From: Eve Hearsey
Sent: 09 March 2012 14:16
To: Planning.Responses
Subject: FW: FG/16/12 - Minor Material Amendment - Asda (Country Fayre), Littlehampton Road, Ferring.
Attachments: Compack8 brochure new.pdf; Flexy II PCA 0208.pdf

Please could this be scanned and attached to the above application under Consultation - Environmental Health
 Thanks

Proposed Ground Floor Plan

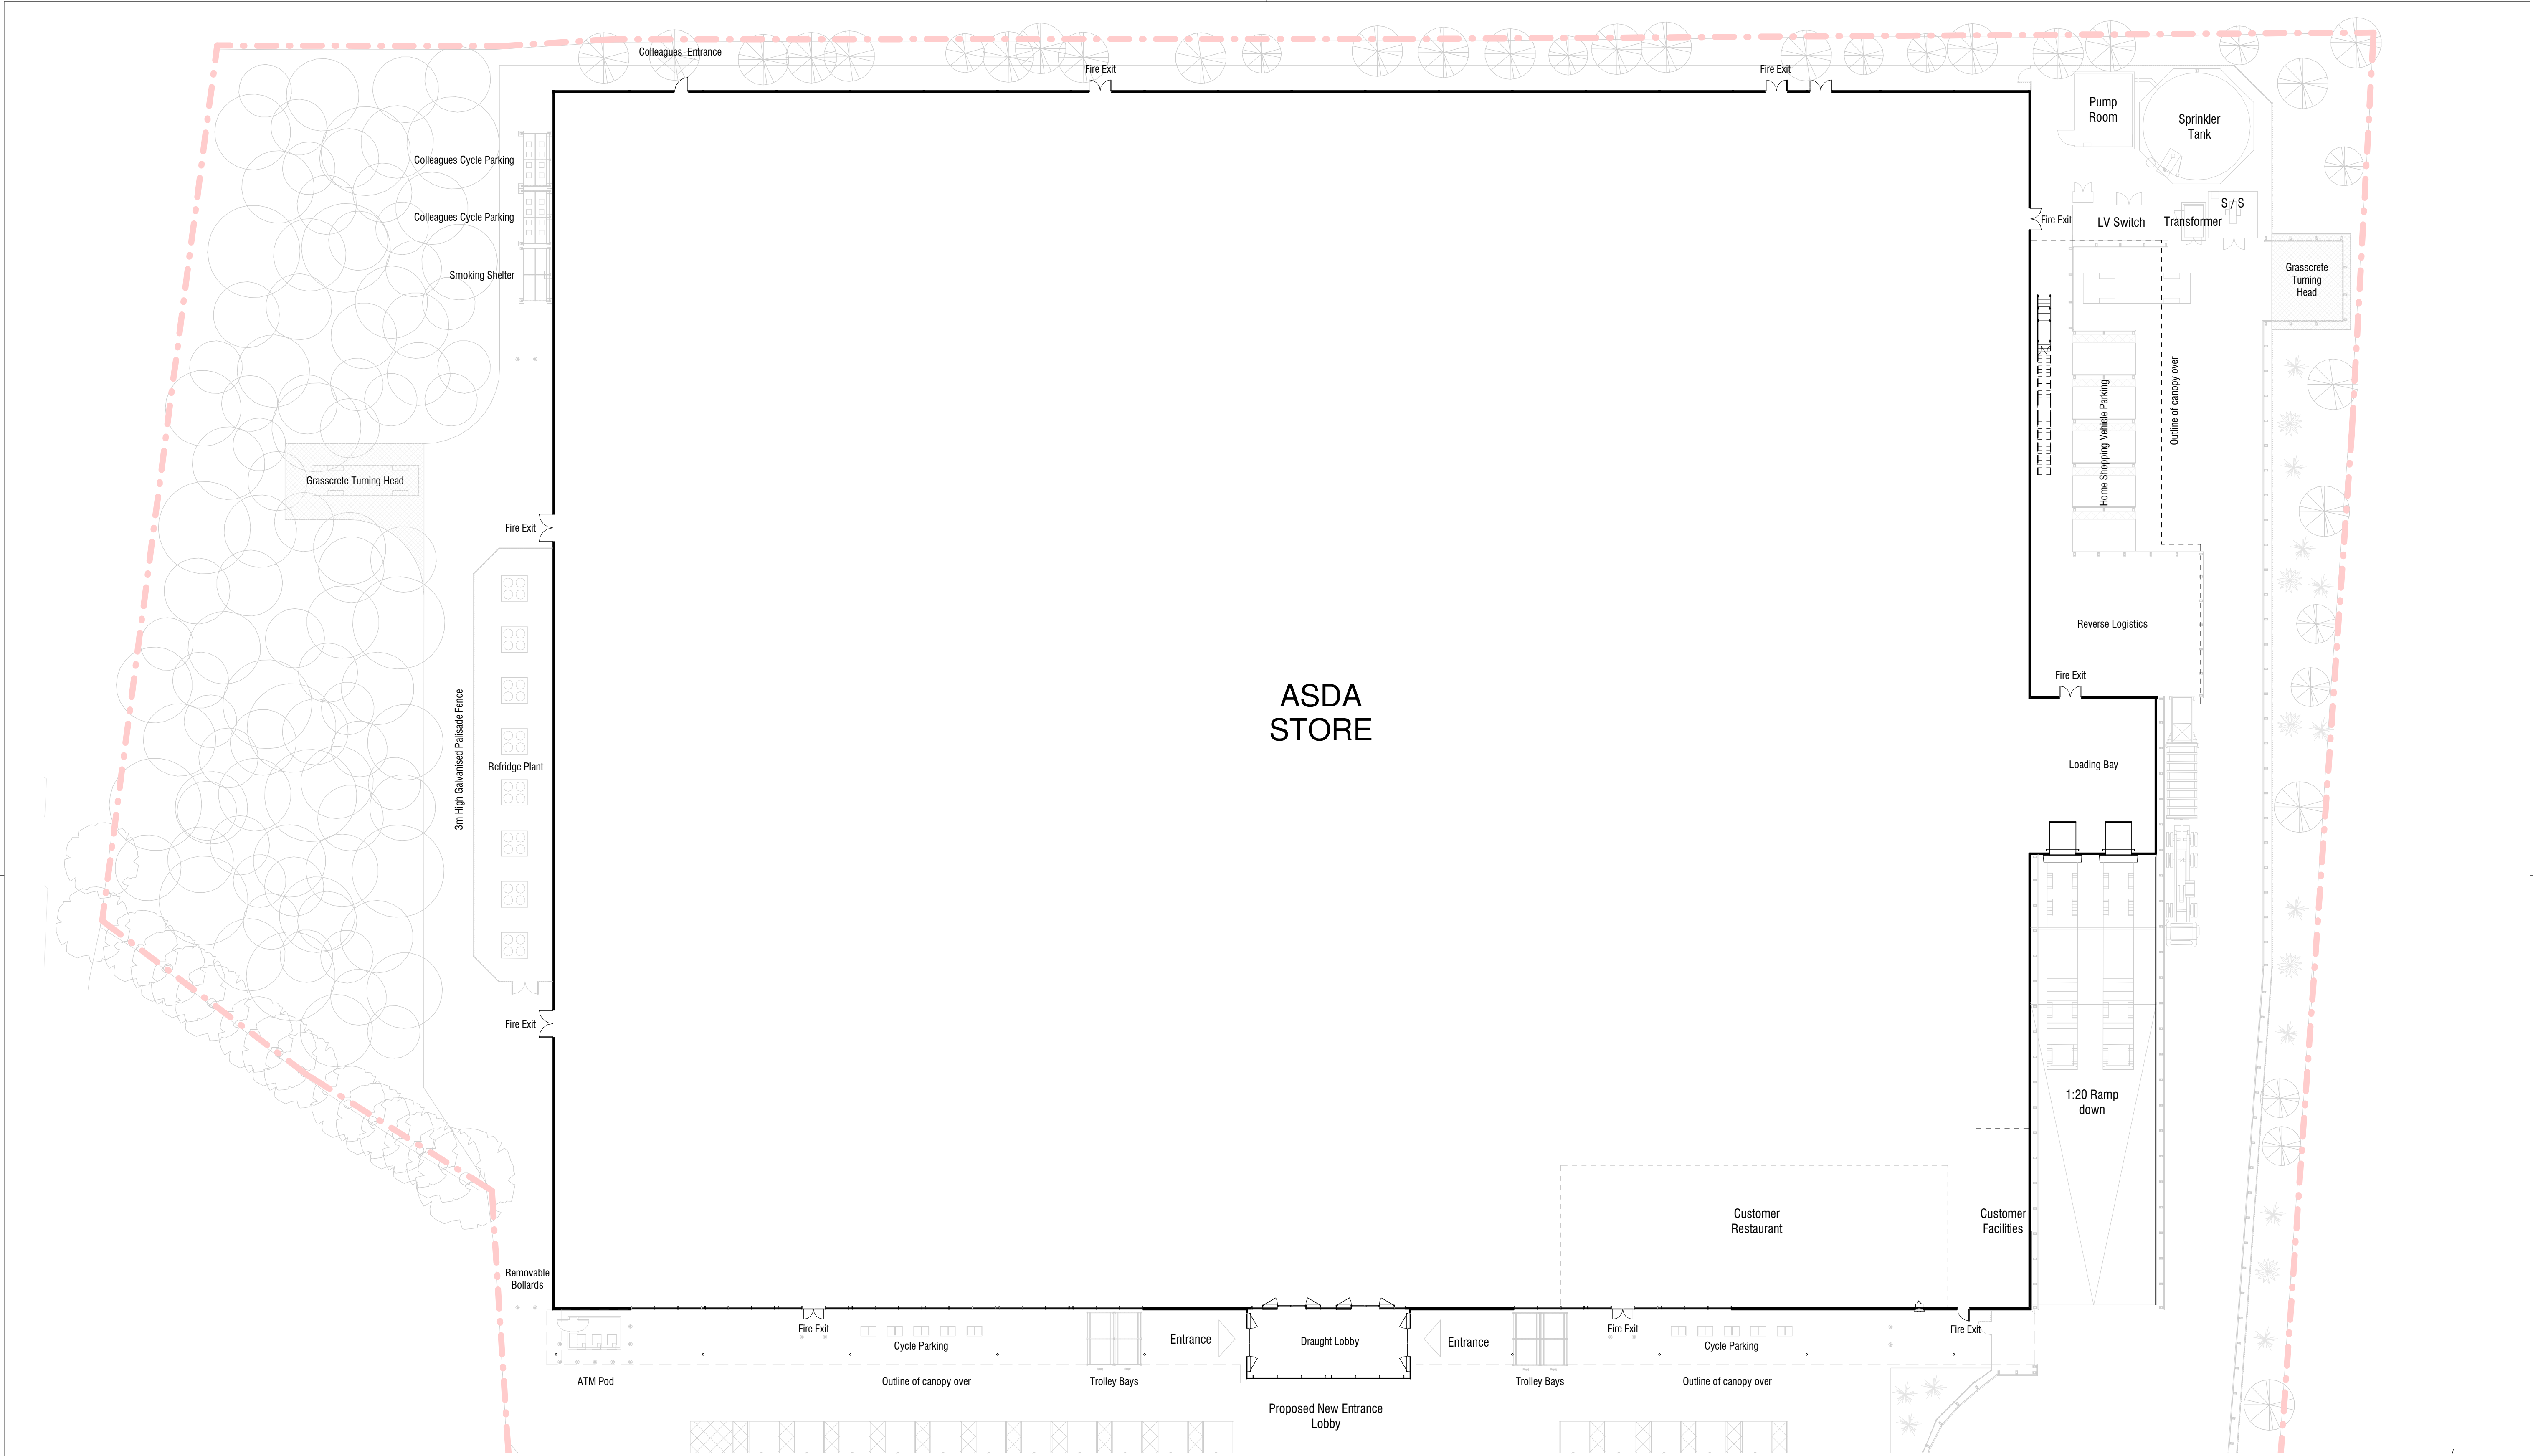
units on the roof together with the refrigeration plant on the east side of the supermarket and the pump room etc. on the west side of the building, particularly with regard to the surrounding residential properties.

Proposed Roof Plan

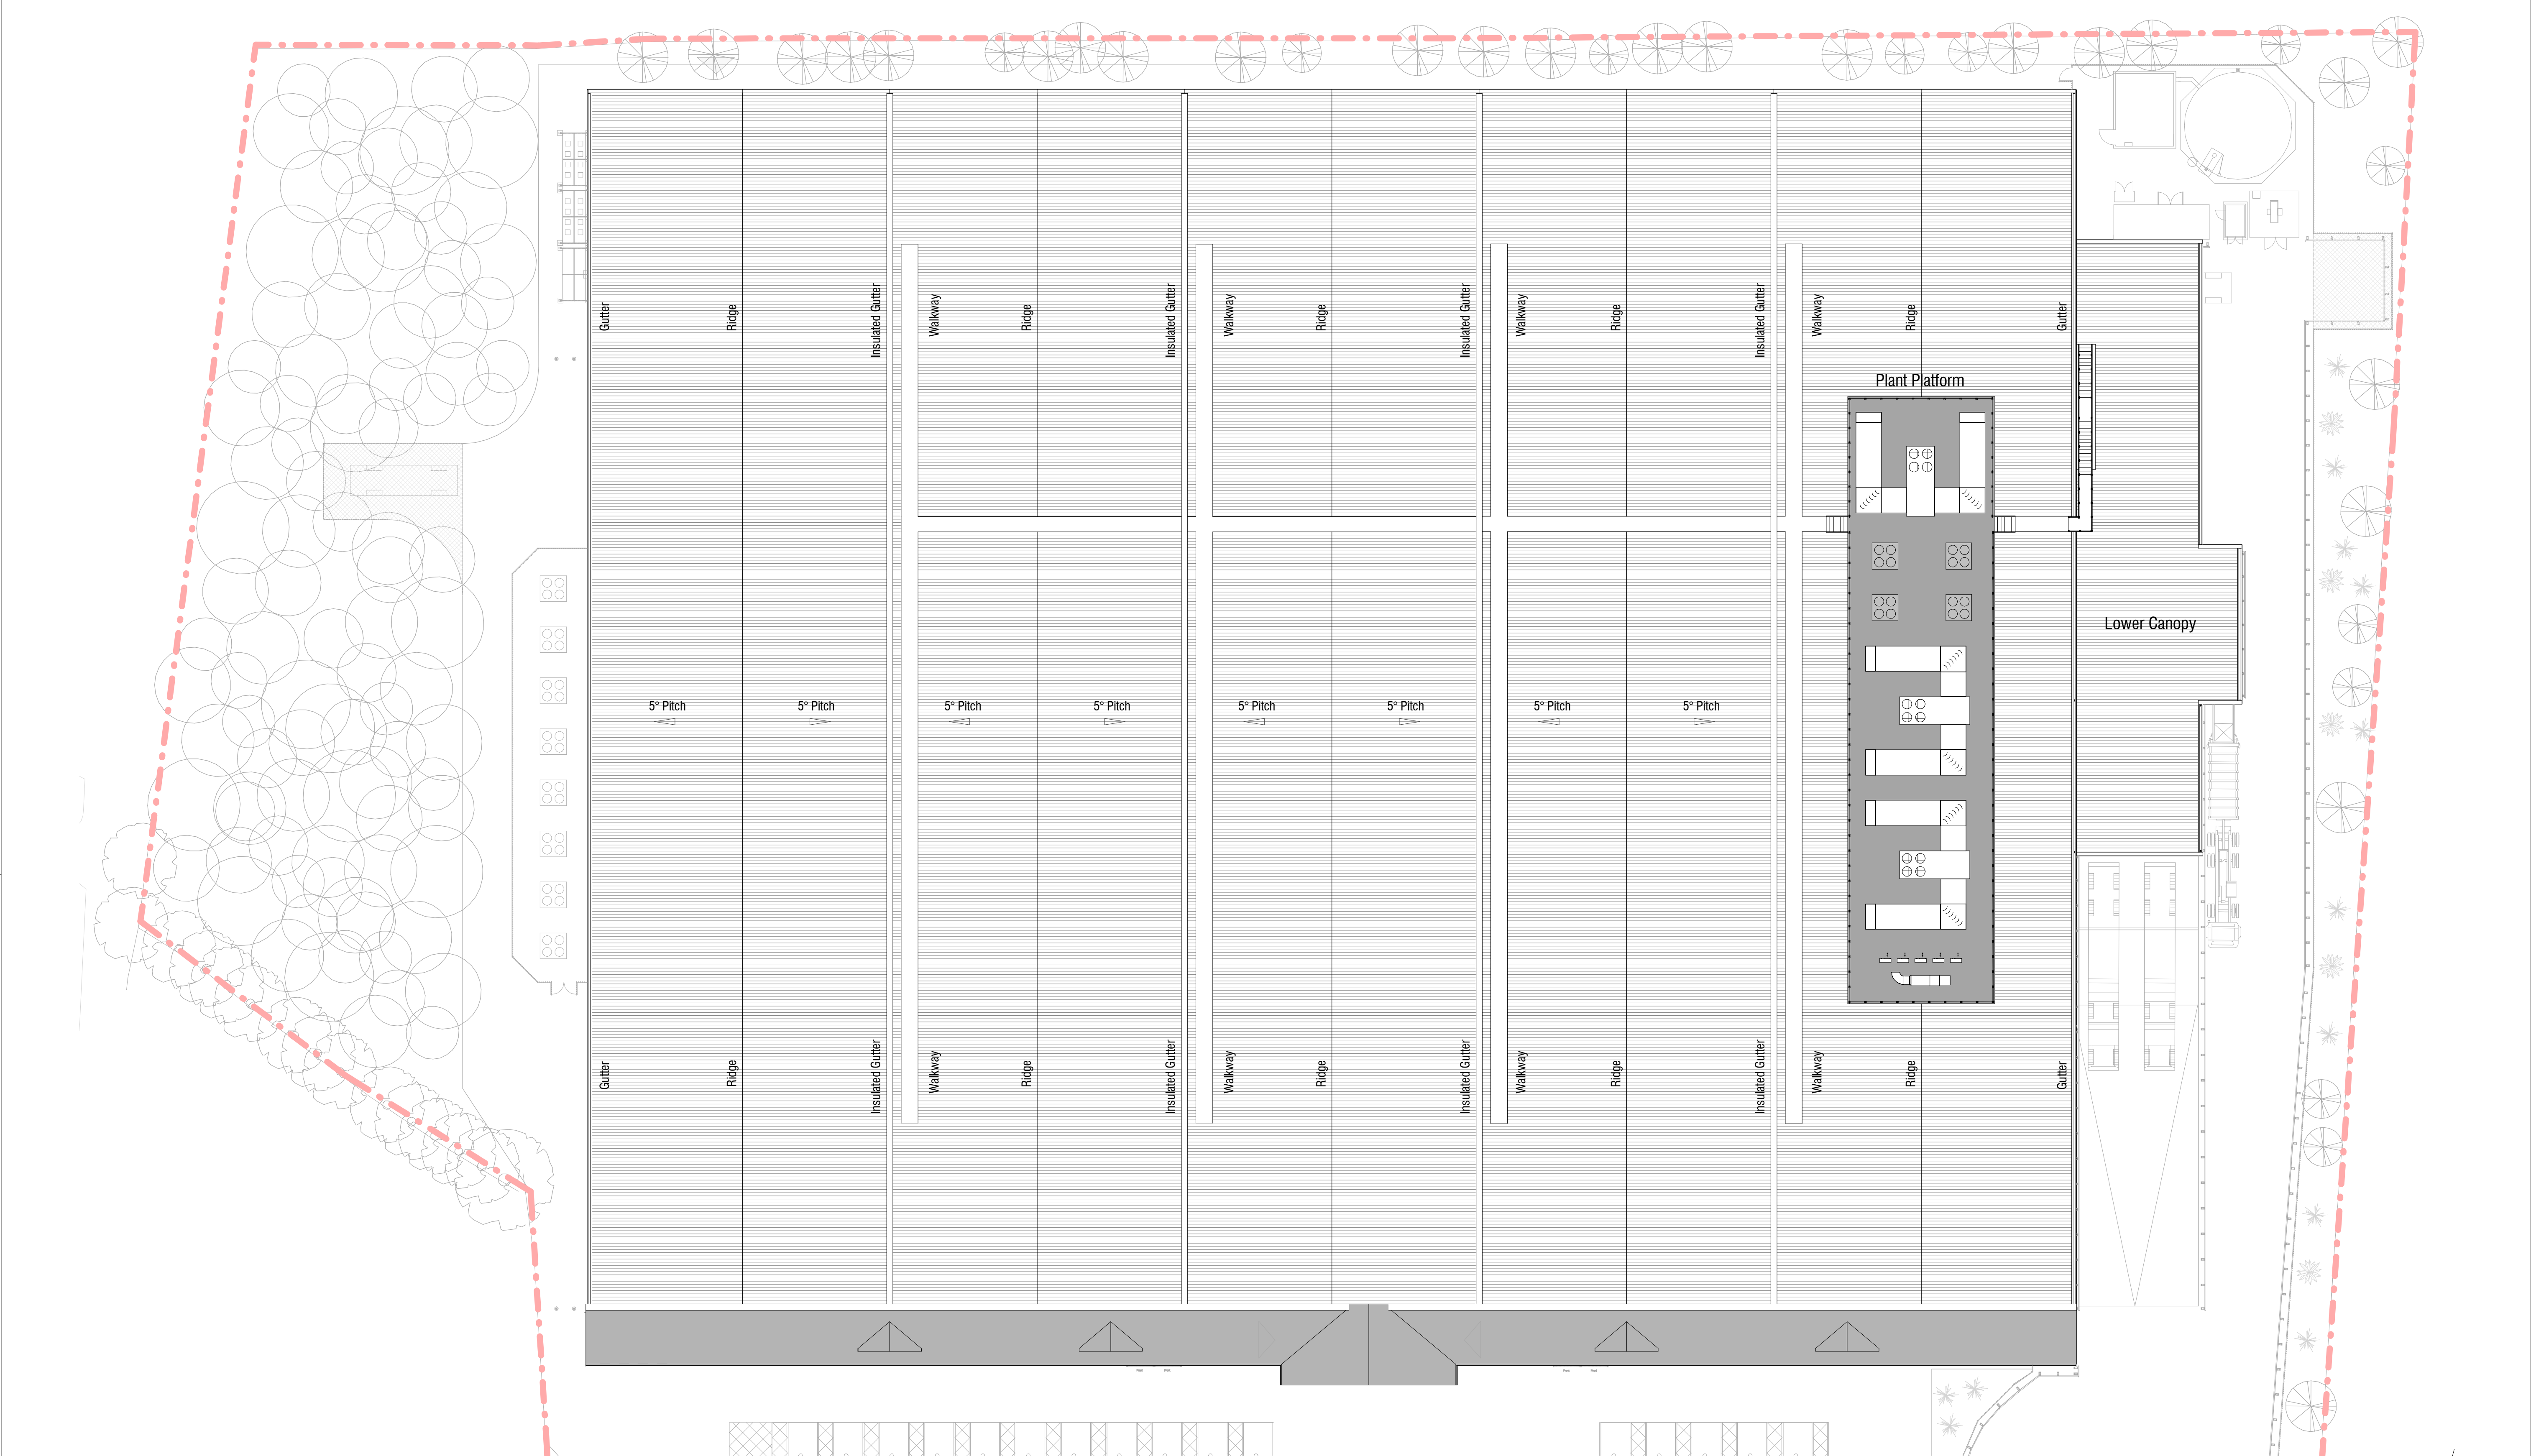
No information is provided in respect of noise produced by the plant, existing background noise levels, or predicted noise levels at nearest sensitive premises, so definitive comment is not possible. It is noted that the scheme does not propose any screening to either plant compound. I did consider the the potential impact of noise from plant and in view of the separation distance to the nearest sensitive residence ("Huntley" @ 100m+) I did not consider that noise from modern, well maintained plant at this distance was likely to be significant. Noise arising on this site may have a greater impact on future sensitive development in closer proximity and may be a consideration in any application for such development.

With regard to the question on Legionnaires Disease we can confirm that the cooling for the air handling plant is air-cooled. There is a sealed heat reclaim system that utilises a water/glycol solution as a heat transfer medium. It is used to recover waste heat from the HT/LT pack for use in pre-heating domestic hot water. There are no cooling towers, or condensers that use evaporative cooling.

The proposed refrigeration plant is designed on dry air cooled condensers and does not include a water cooling tower or evaporative condensers.
